Recommendation Report for Planning Permission for Works or Extension to a Dwelling

REF NO: BN/39/25/HH

LOCATION: Greenings
Eastergate Lane
Eastergate
PO20 3SJ

PROPOSAL: Removal of previous extensions and construction of a two storey rear extension, single storey side extension, replacement front porch, new ground floor front bay windows, external cladding and re-rendering, and realignment of front entrance drive.

DRAWING TITLE
 PROPOSED FLOOR PLANS

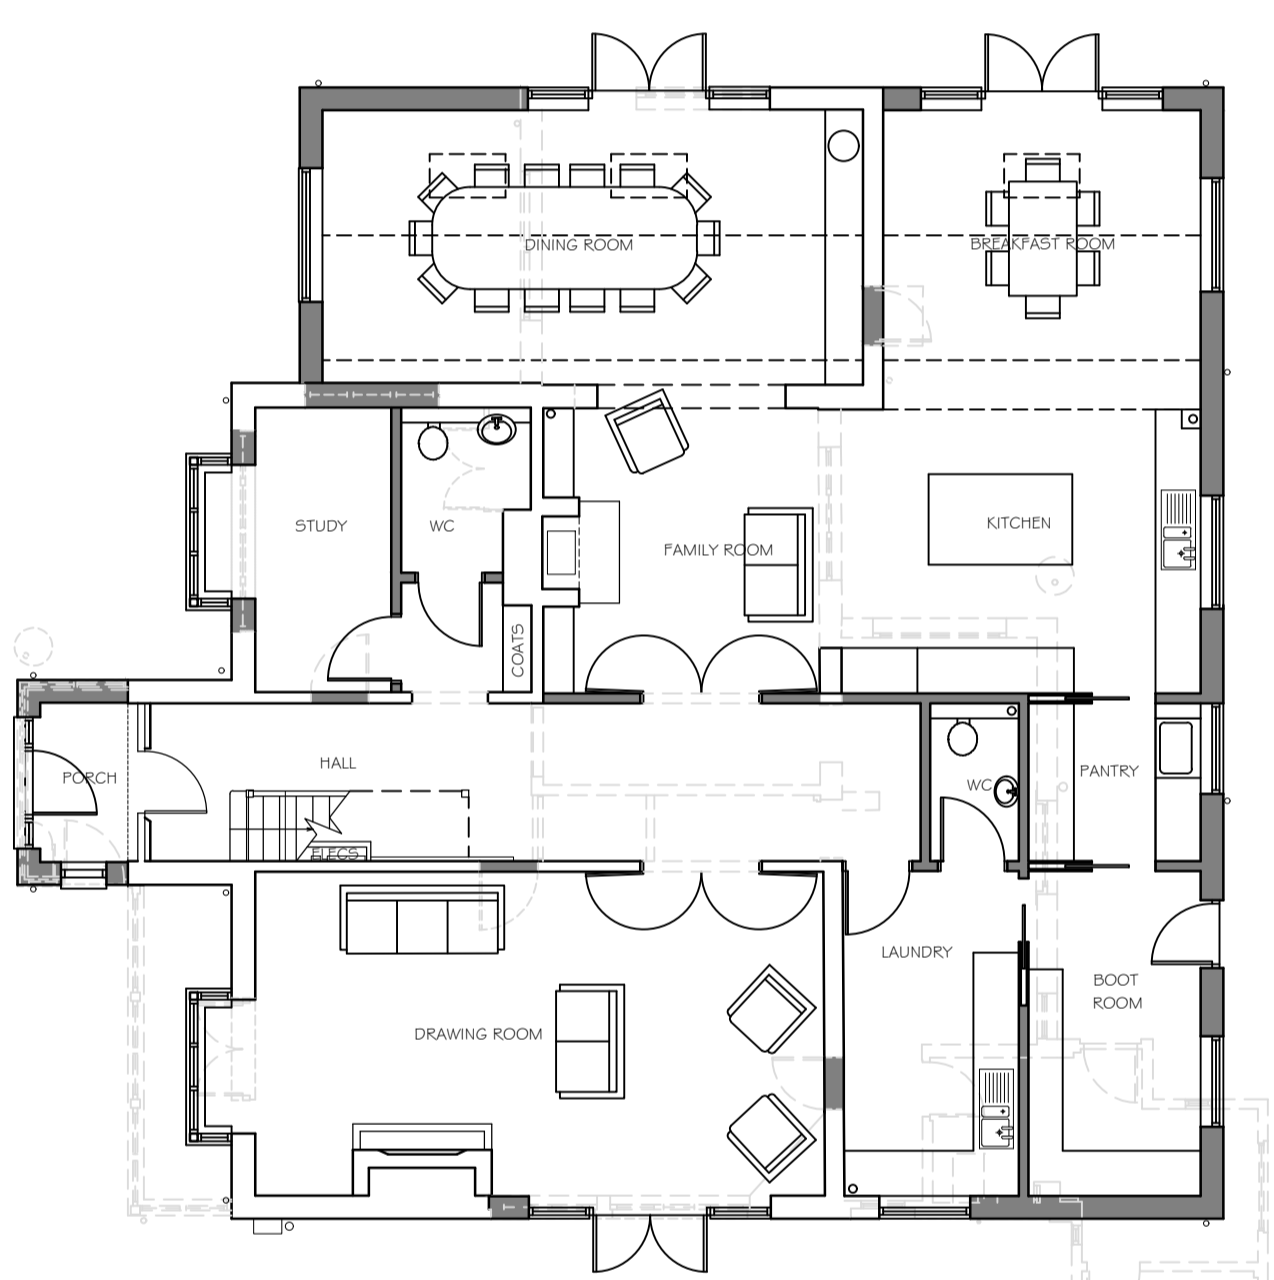
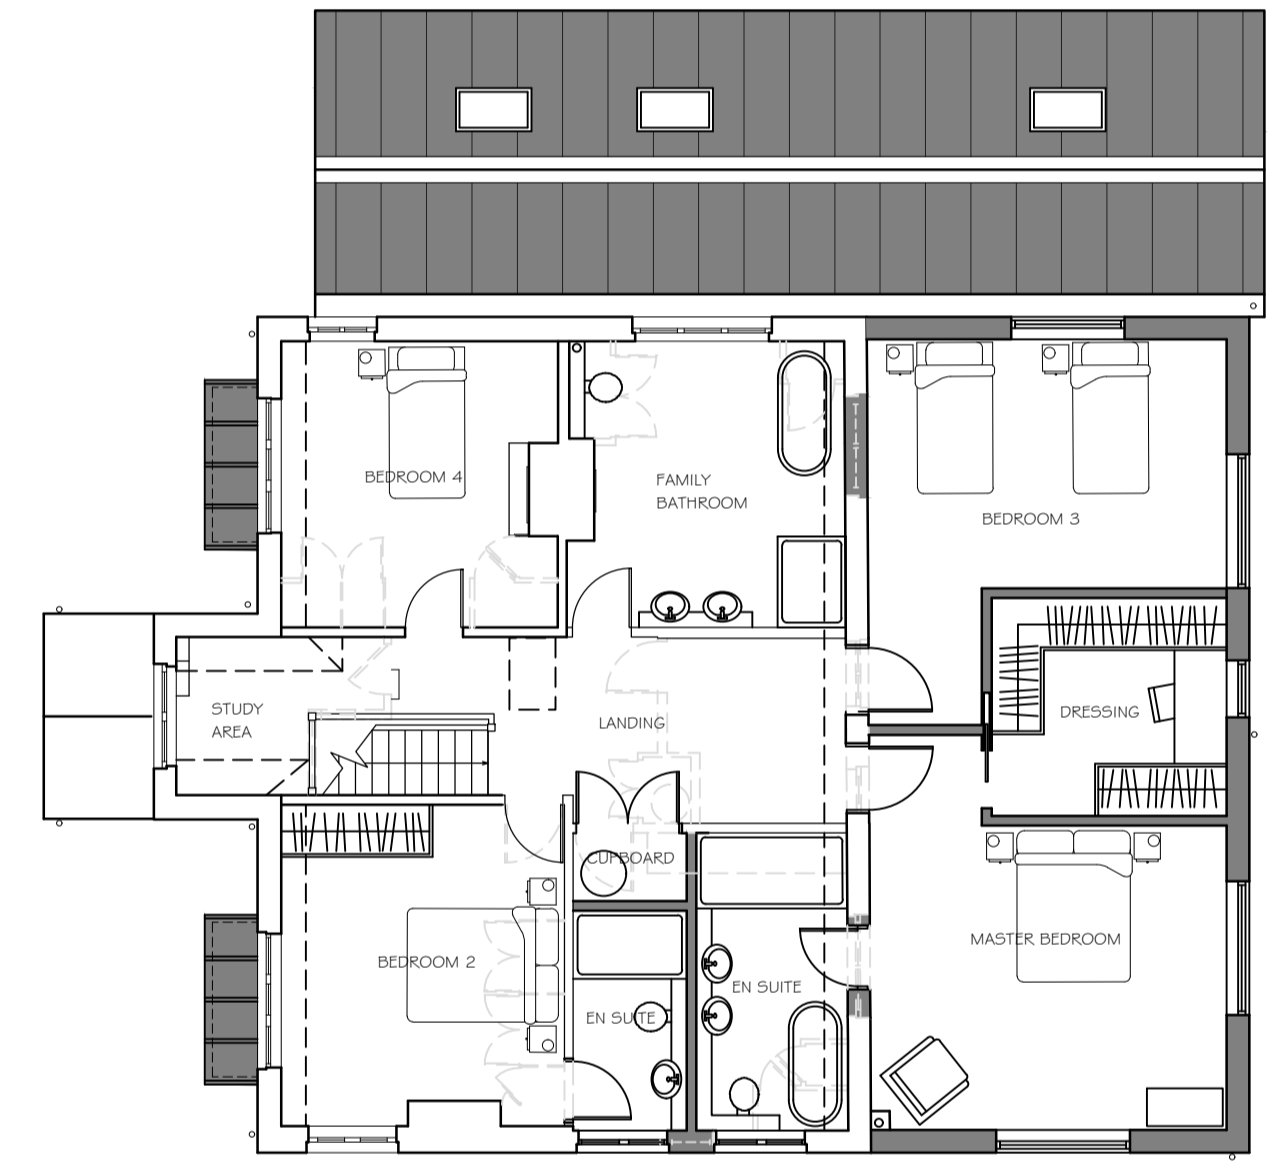
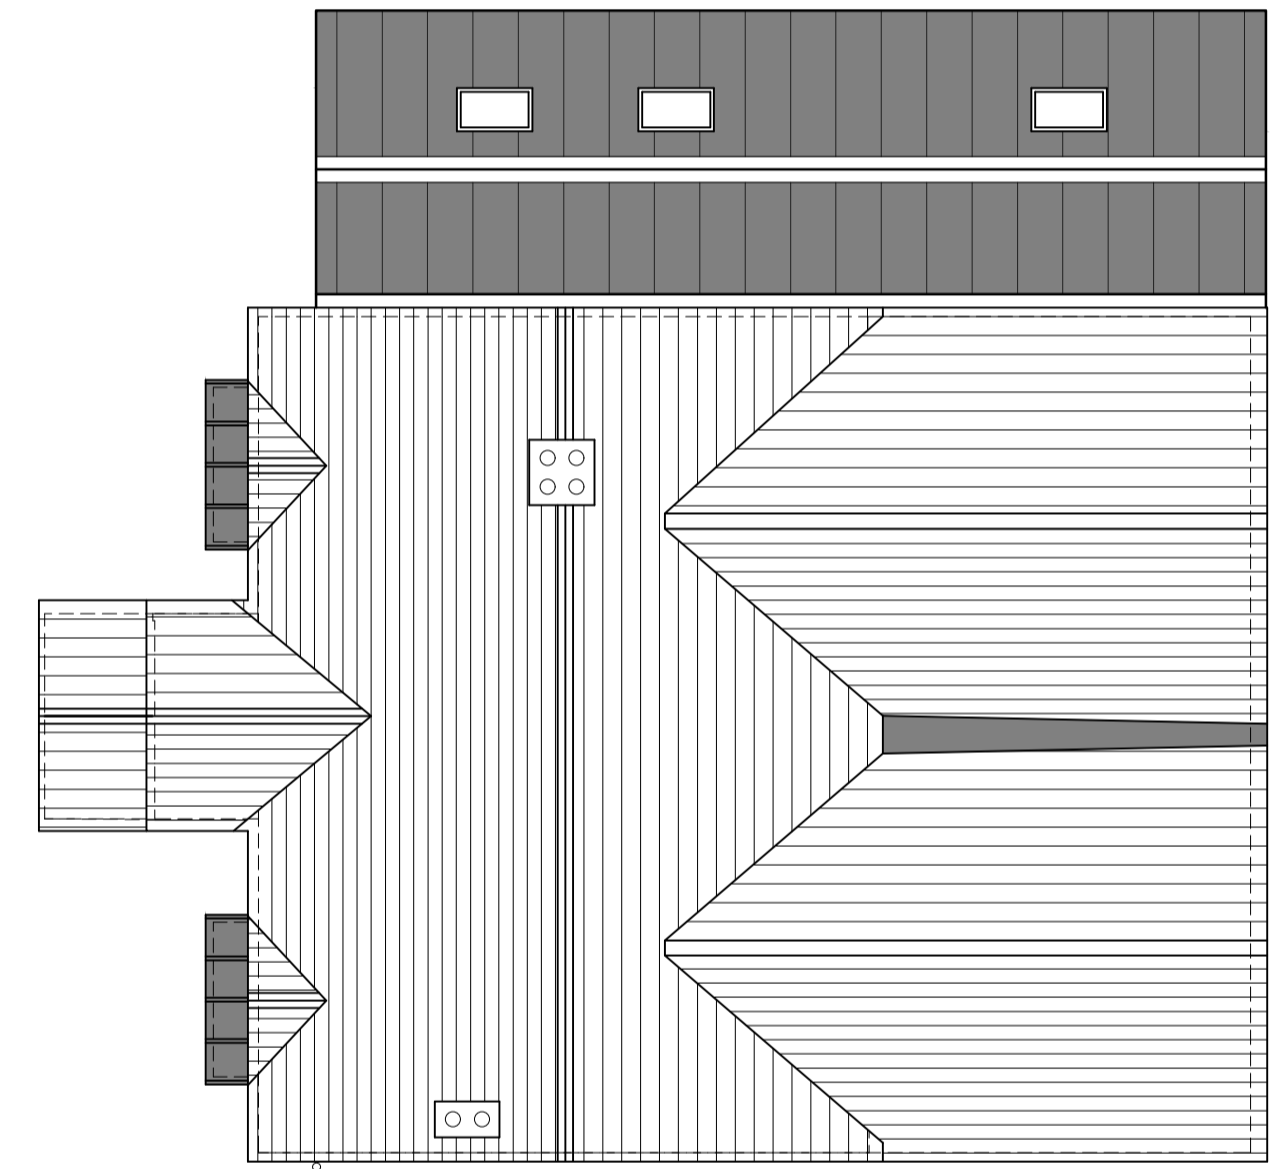
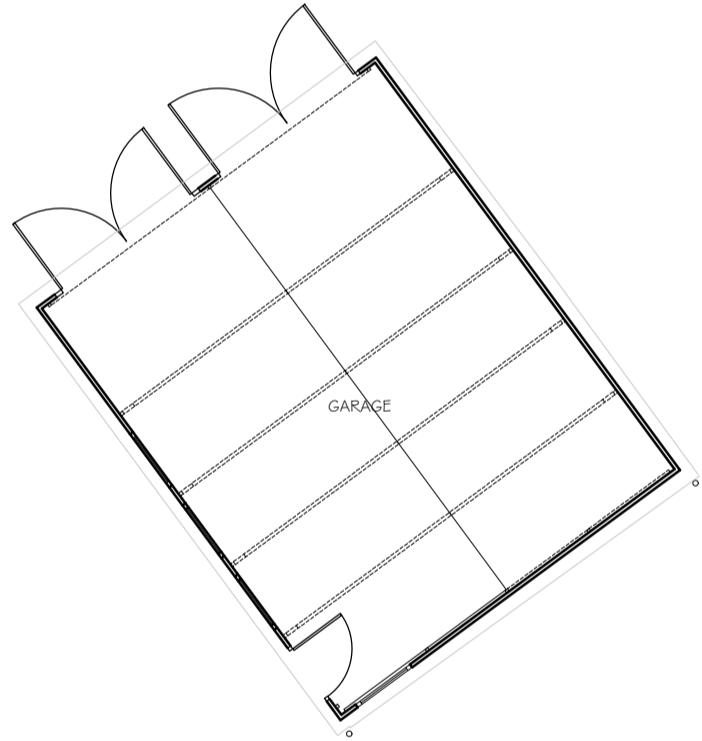
The site is a two storey detached property with existing detached outbuildings to the rear. The proposal is for a two storey rear and single storey side extension, replacement porch, bay windows and alterations to external materials. The proposed side extension would have a width of 4m and it would extend in line with the rear elevation of the proposed rear extension. The side extension would have a pitched roof, with a ridge height of 4m. The addition is distinct from the main dwelling, but would remain visually subservient, in accordance with policy D DM4 of the Arun Local Plan. The proposed bay windows would be located either side of the main entrance, following the demolition of the existing lean-to on this elevation. The bay windows would alter the appearance of the dwelling, resulting in the front elevation having the appearance of a principal elevation. The bay windows would project 0.6m from the front elevation. The proposed replacement porch would have the same footprint as the existing, but would have a pitched roof. The ridge height would measure a maximum of 3.7m, which is higher than the maximum height of the existing porch roof. The porch would not harm the character of visual amenity of the property.

The proposed two storey rear extension would have a depth of 5m from the rear elevation. The extension would span the width of the rear of property, and it would adjoin the side extension. The extension would have two pitched roof sections, which would be set down from the main ridge height. The extension would remain visually subservient to the main dwelling, and is acceptable in terms of its scale and massing.
